**KIRKLEES METROPOLITAN COUNCIL
INVESTMENT & REGENERATION SERVICE**

DELEGATED DECISION TO DETERMINE PLANNING APPLICATIONS

Reference No: 2020/62/93004/E
Site Address: 35, Chadwick Crescent, Dewsbury, WF13 2JF
Description: Erection of two storey side extension and alterations
Recommending Officer: Jennifer Booth

DECISION – REFUSED

block plan

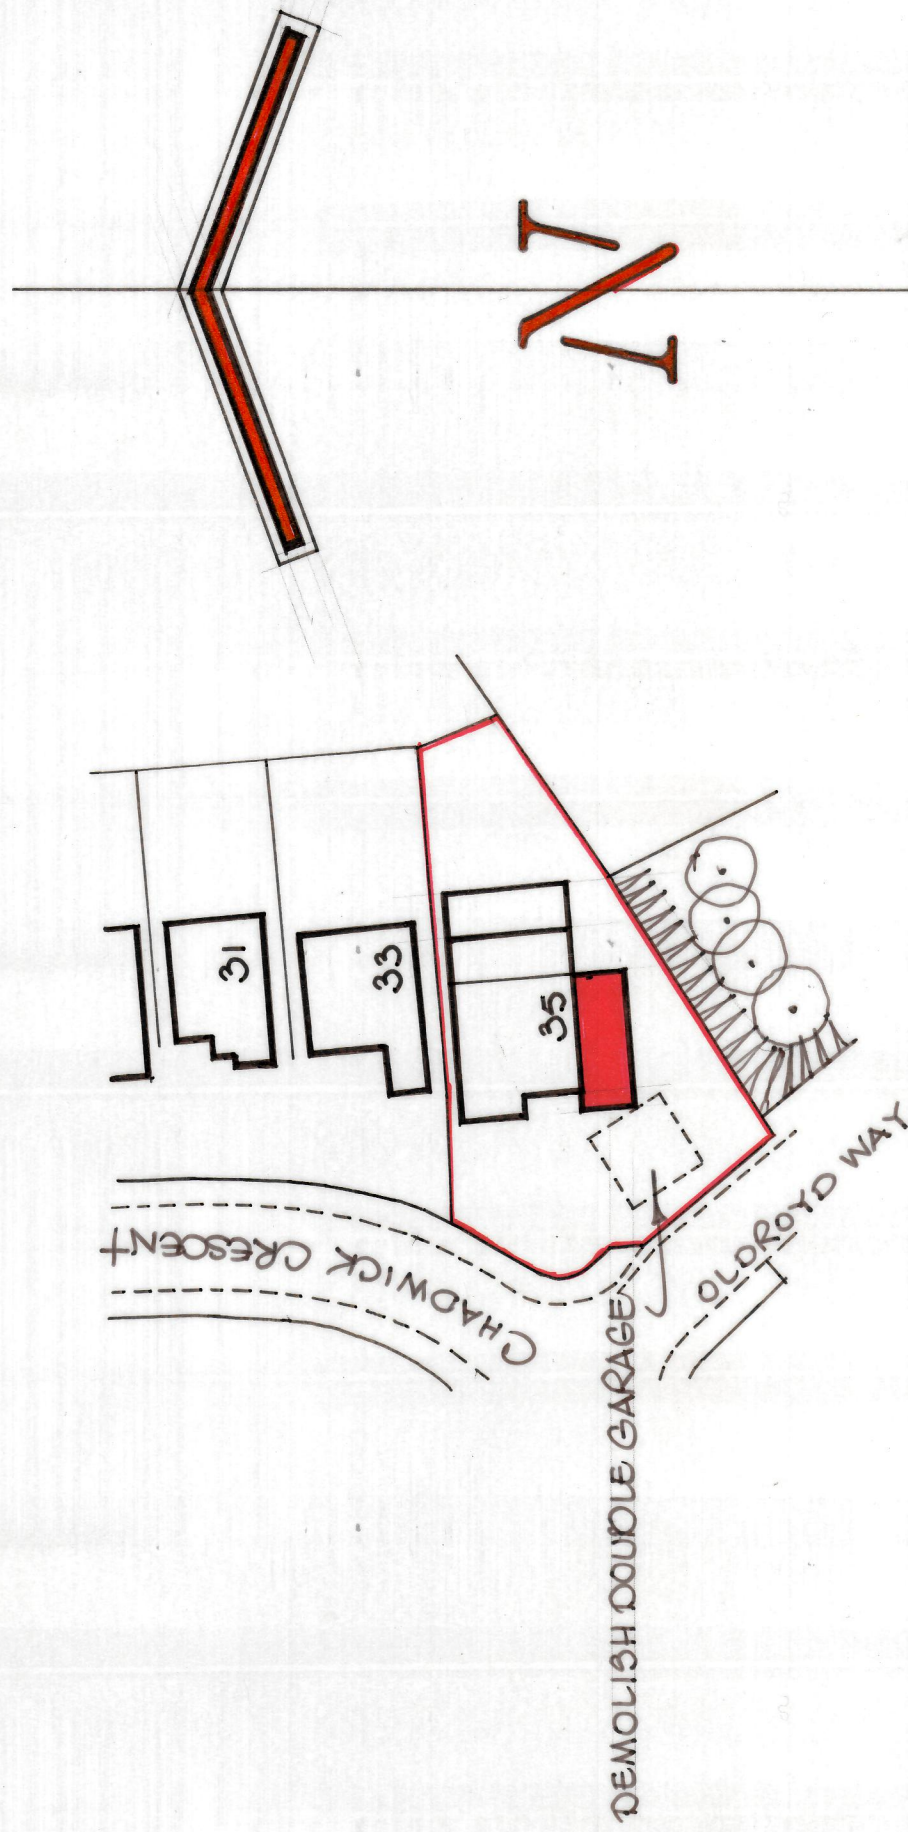
The extension is proposed within close proximity to a number of healthy trees directly adjacent to the curtilage of the dwelling and, as such, the extension is likely to be within the root protection area. Furthermore, the extension would potentially result in encroachment on the canopy. No information has been submitted on mitigating the harm to the trees and, as the potential harm to the protected trees would likely impact upon their viability, the proposed side extension would not be acceptable in terms of policy LP24 and LP33 of the KLP.

Furthermore, the proposed two-storey side extension would have the potential to harm the root systems of the adjacent protected trees and result in pressure to prune or even fell the protected trees. No information has been supplied by the agent which would illustrate the harm could be either justified or sufficiently mitigated. The proposal, therefore, fails to comply with LP33 of the KLP and advice within chapter 15 of the NPPF.

2. The application has failed to demonstrate sufficient justification for the probable harm to mature trees immediately adjacent to the site, given the proximity to the root protection area and crown spread, within an area protected by a Tree Preservation Order. These trees provide a high amenity value within the local environment. The application is, therefore, contrary to Policy LP33 of the Kirklees Plan and Chapter 11 of the National Planning Policy Framework.
